26 October 2016

Our Ref: 142580

**RE: BCA COMPLIANCE CAPABILITY STATEMENT
UNSW BIOLOGICAL SCIENCES STAGE 2 SECTION 96 APPLICATION**

Sheet Name  
**FLOOR PLAN - GROUND**

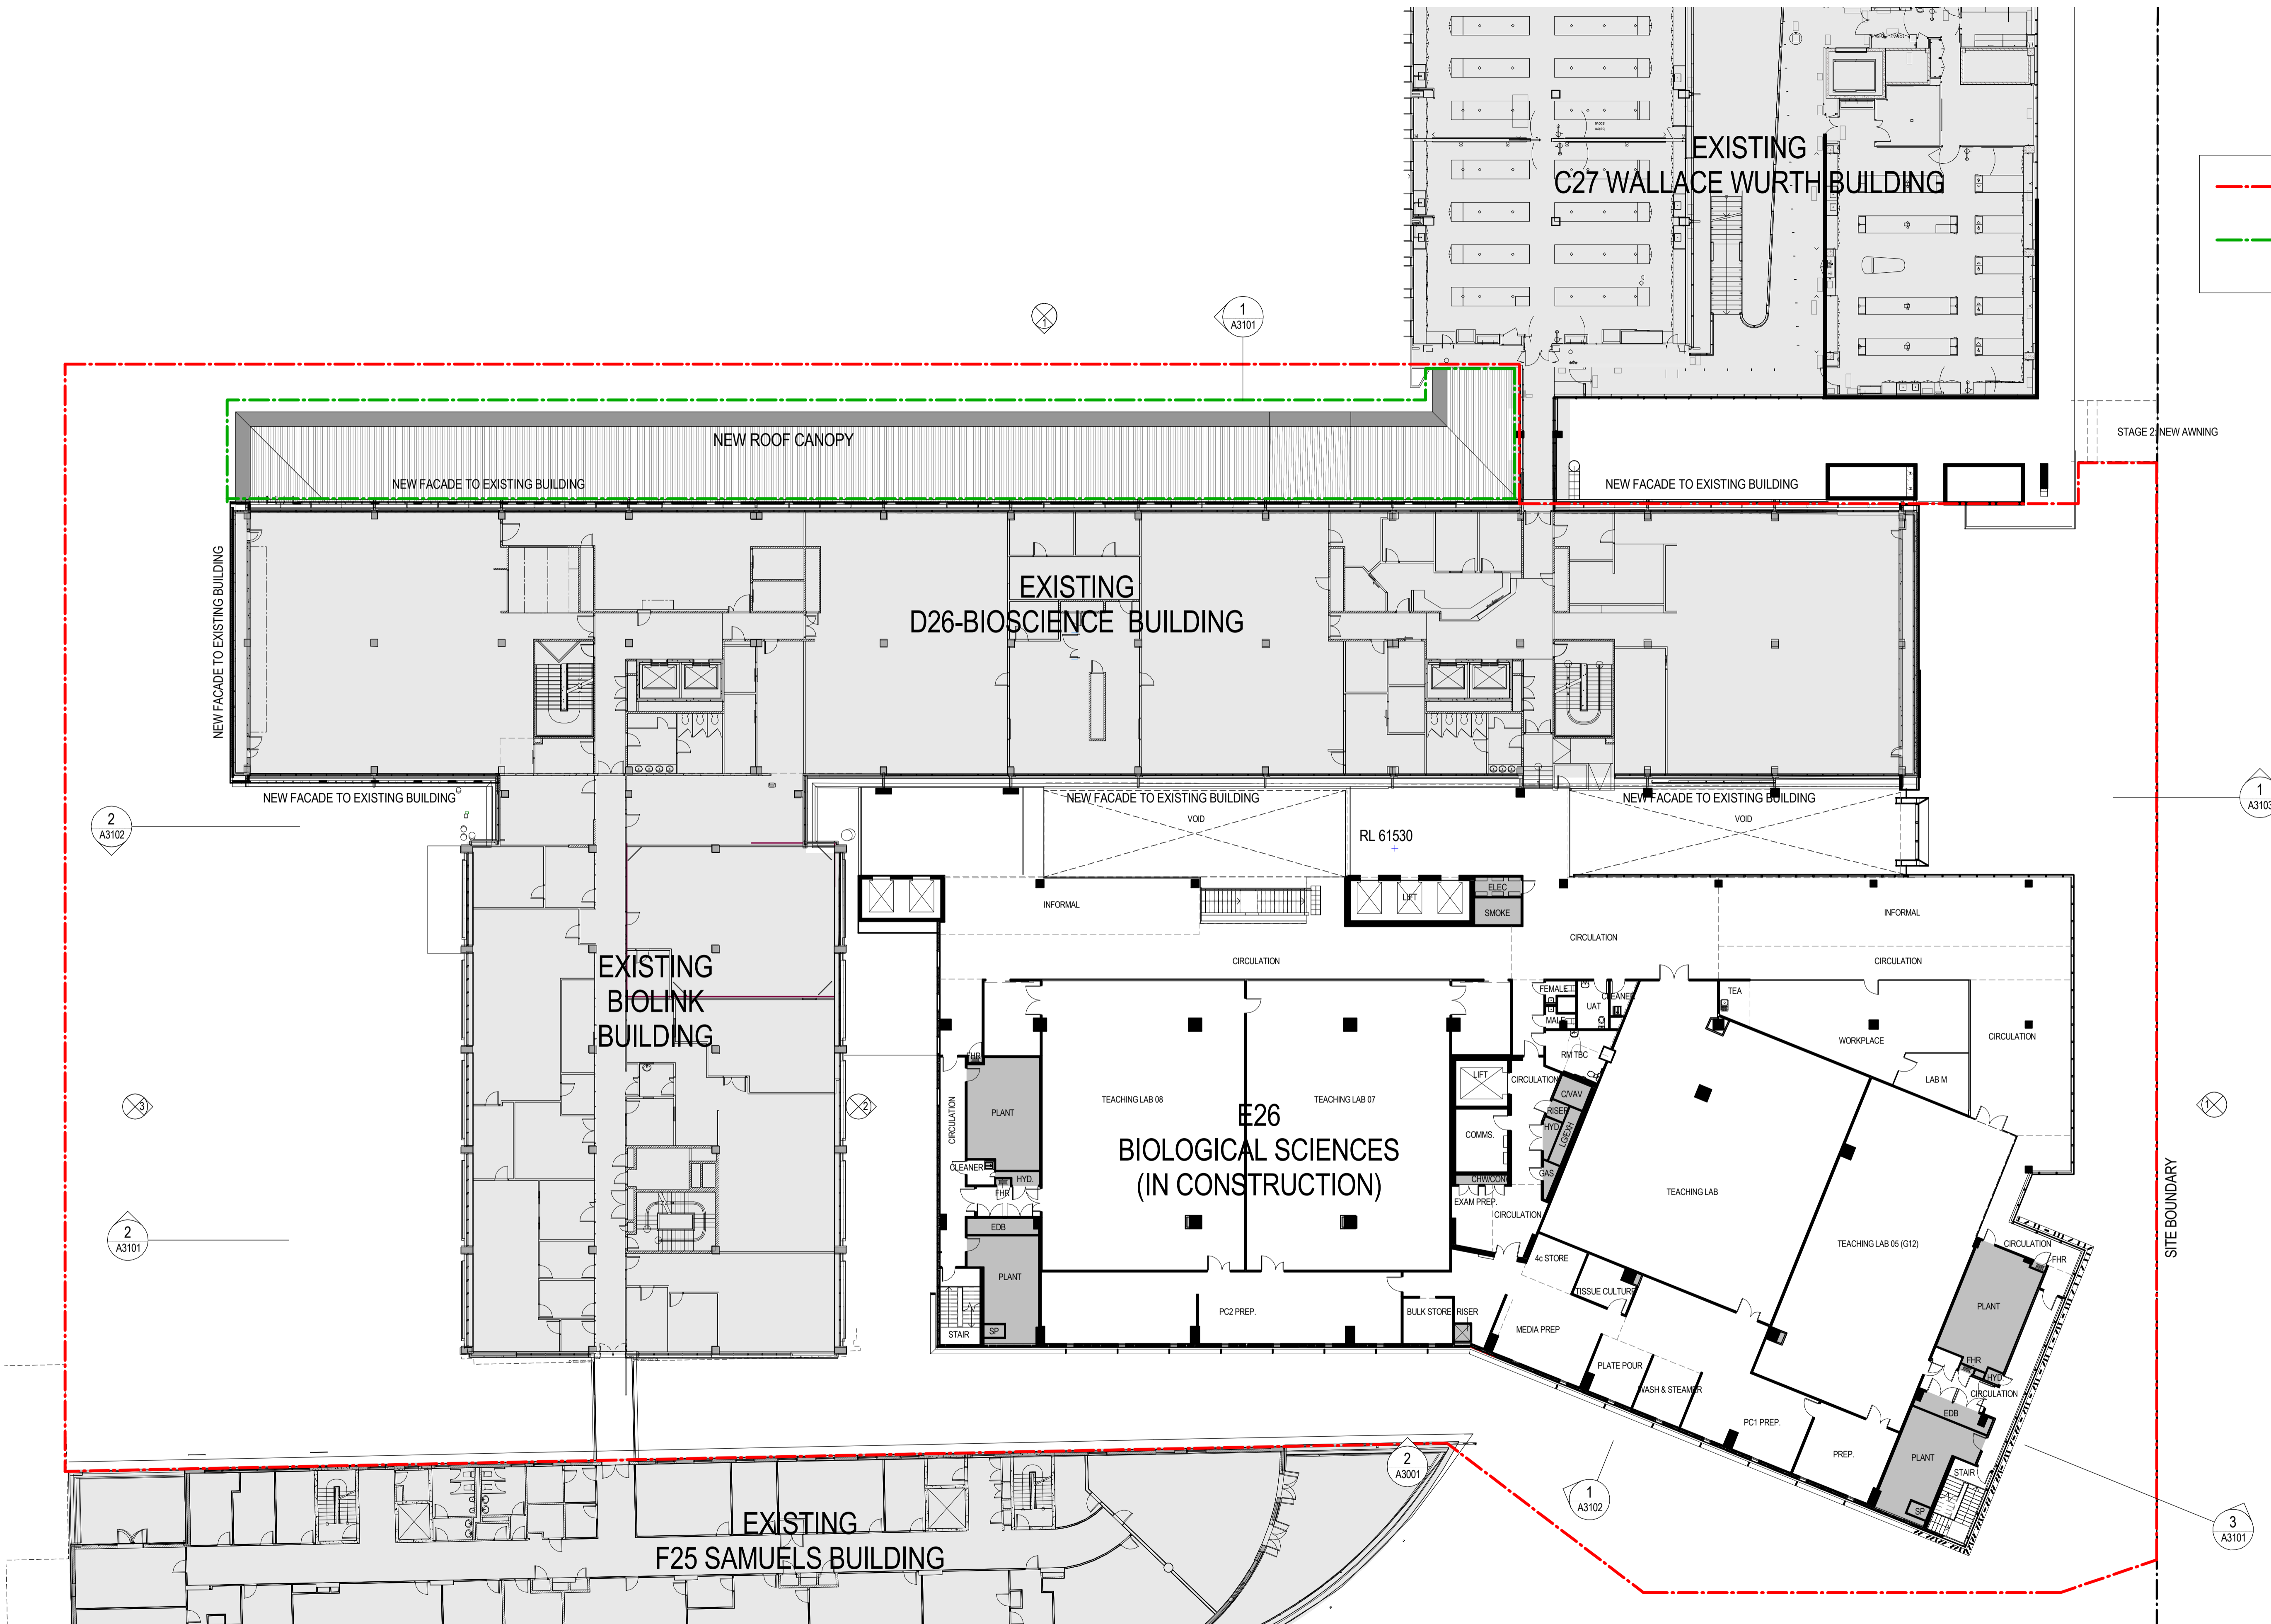
- 2.6 Complying egress from the Ground Floor of the south west part of D26 and the Biolink relies on access being available into the western fire isolated stairway. A design change is required to provide for this access. Depending on the location of the access door there may still be a travel distance non-compliance from the D26 south west plant room which may be up to 24 m to a point of choice.

- (a) Distance from the GF toilets in the Biological Sciences Building E26 are 39 m the nearest exit (D26 east exit stair).
- (b) If Biological Sciences Building E26 utility room G009 and workplace G004 does not have access via prep room G005 in an emergency, travel distance to the nearest exit is 45 m to D26 east exit stair.

2.11 Discharge of east stair at GF means that:

- (a) Externally, persons within a 1 m path of travel need to travel within 6 m of unprotected glazing (of Building D26), while traveling to the street.
- (b) Externally, persons travel under a covered area for a length of more than 6 m.

These are non-compliances with D1.7. Item (a) requires fire rating (1 hr) /sprinkler protection internally for a height of 3 m.

Item (b) is to be **performance justified**.

Sheet Name  
**FLOOR PLAN - LEVEL 7**

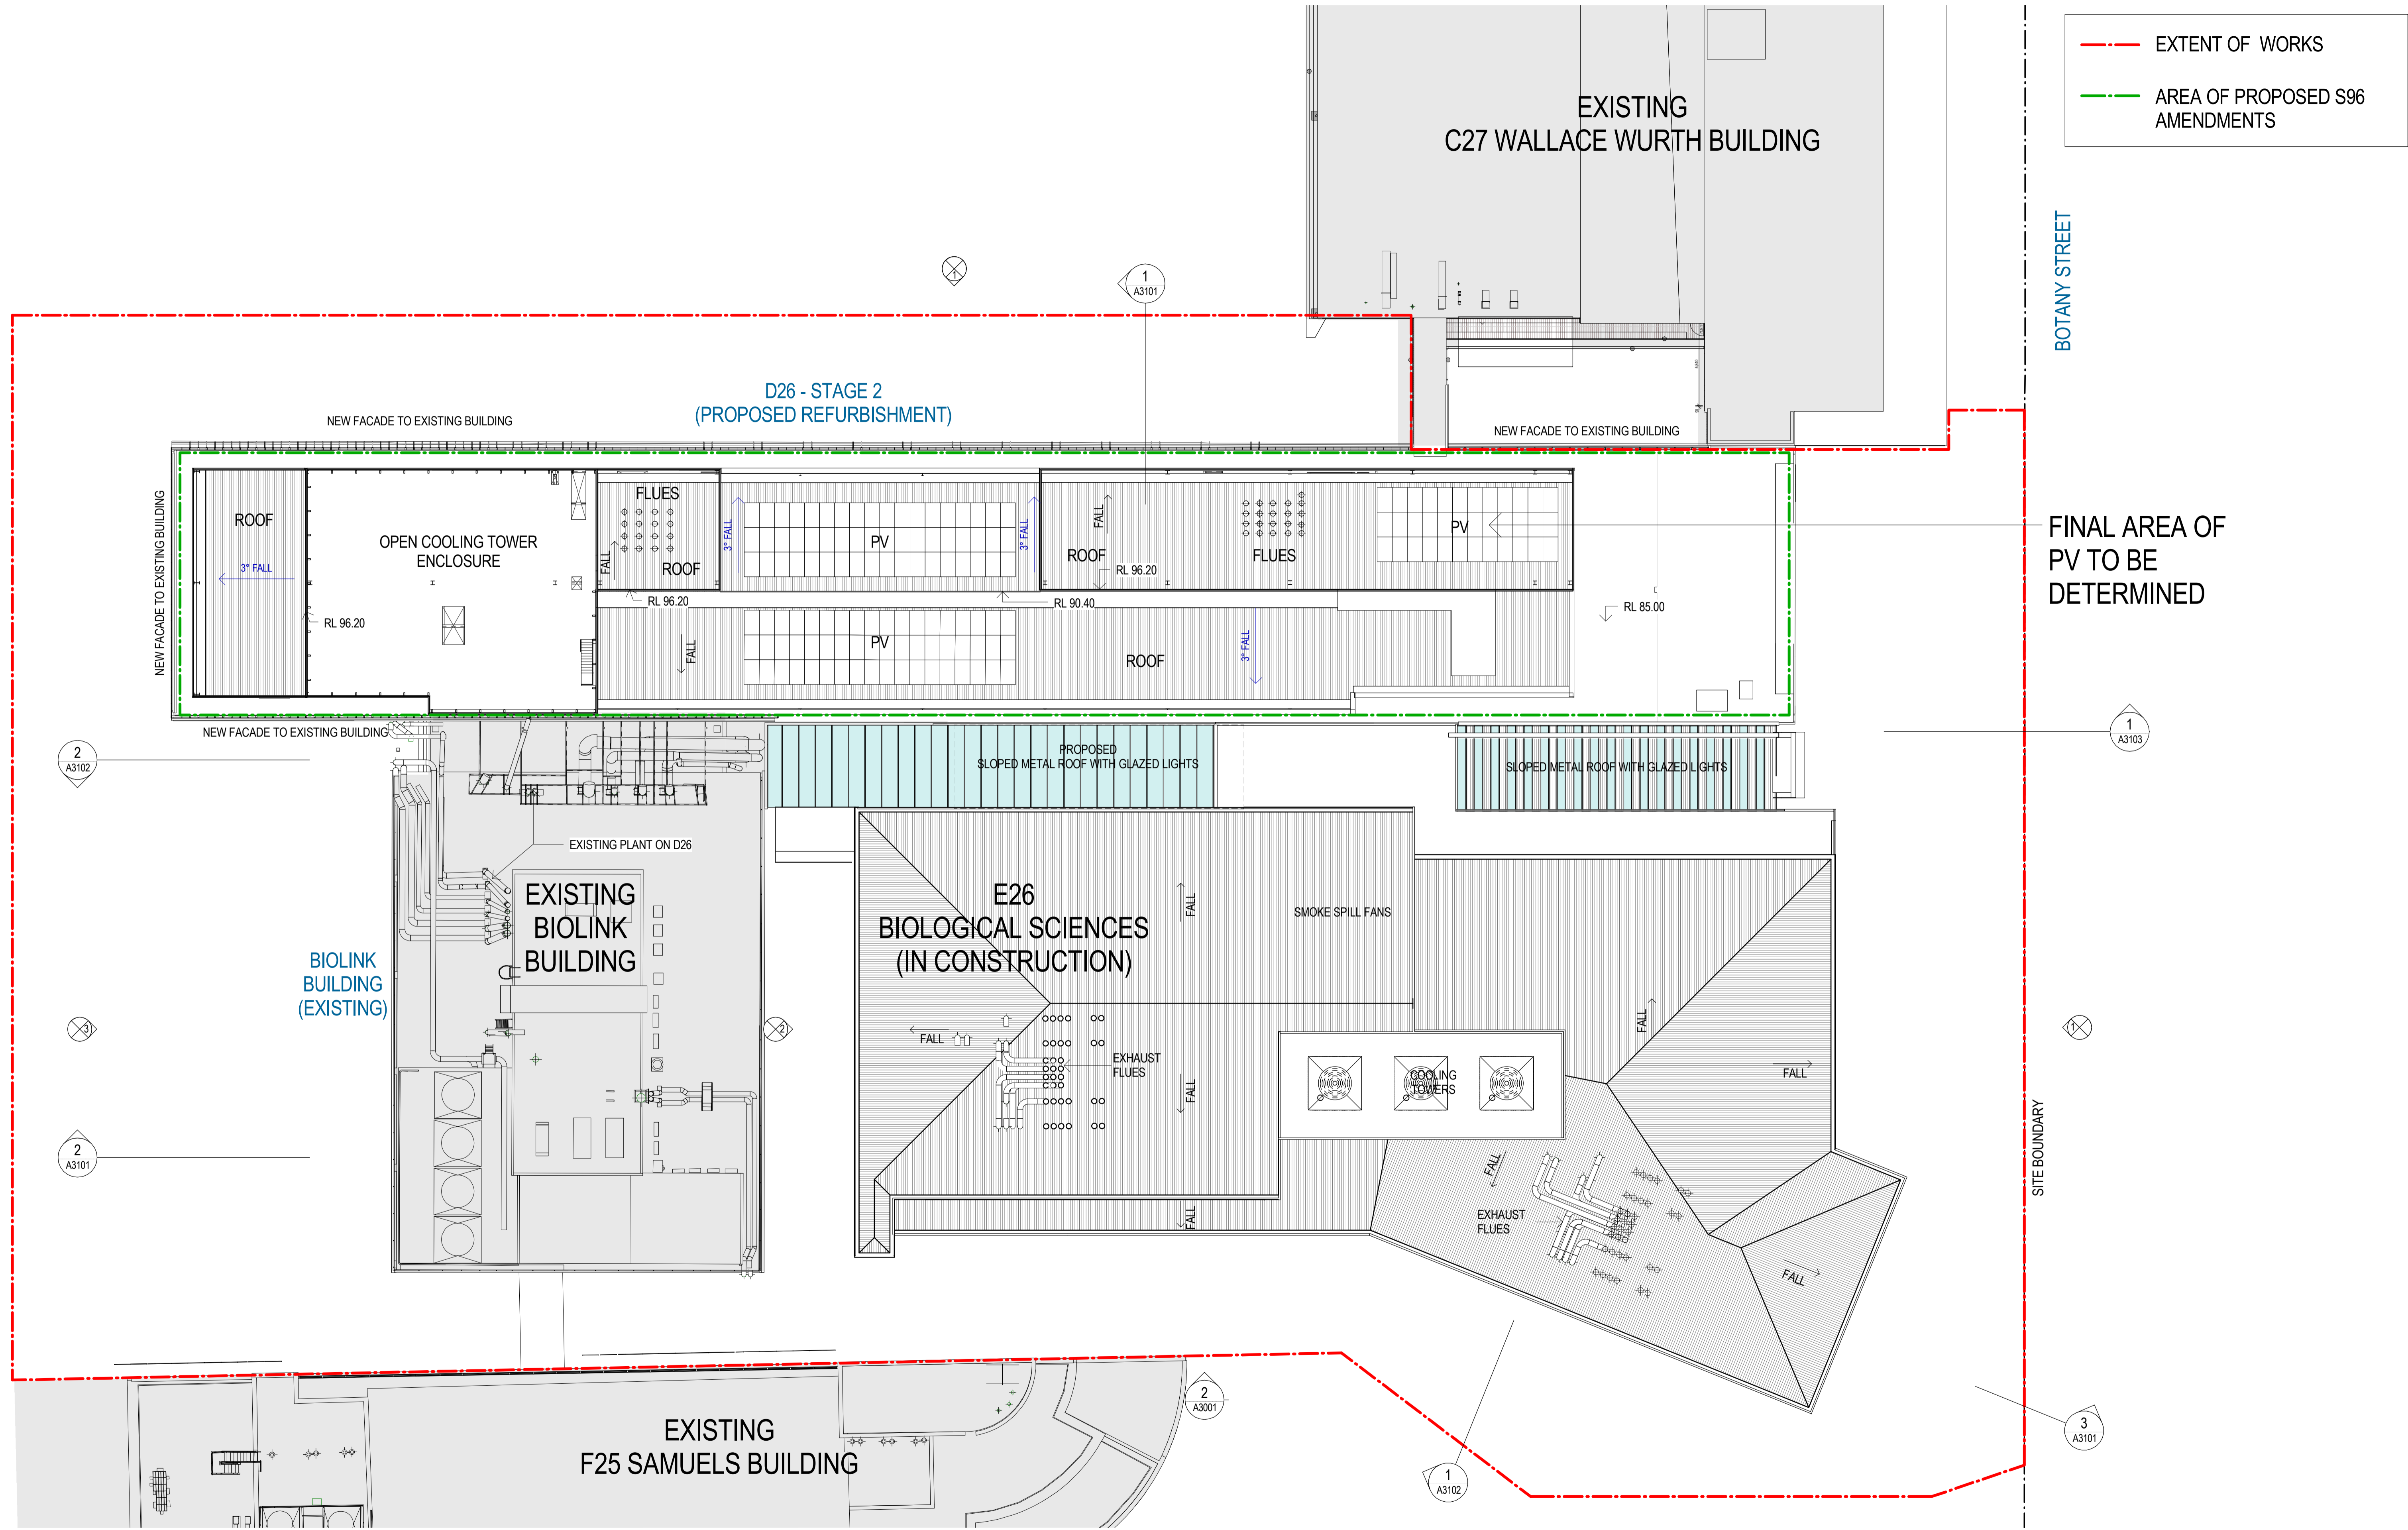
2.9 The west stair connecting Building D26 Level 7 to Level 8 does not comply as follows:

- (a) is not a fire isolated stair (BCA D1.3).
- (b) does not discharge to the outside (BCA D1.7)
- (c) is less than 1 m wide (BCA D1.6)
- (d) goings and risers comply with AS1657 in lieu of BC D2.13.

(e) balustrades comply with AS 1657 in lieu of D2.16.

2.10 Distance between alternative exits on Building D26 Level 7 is 64.3 m
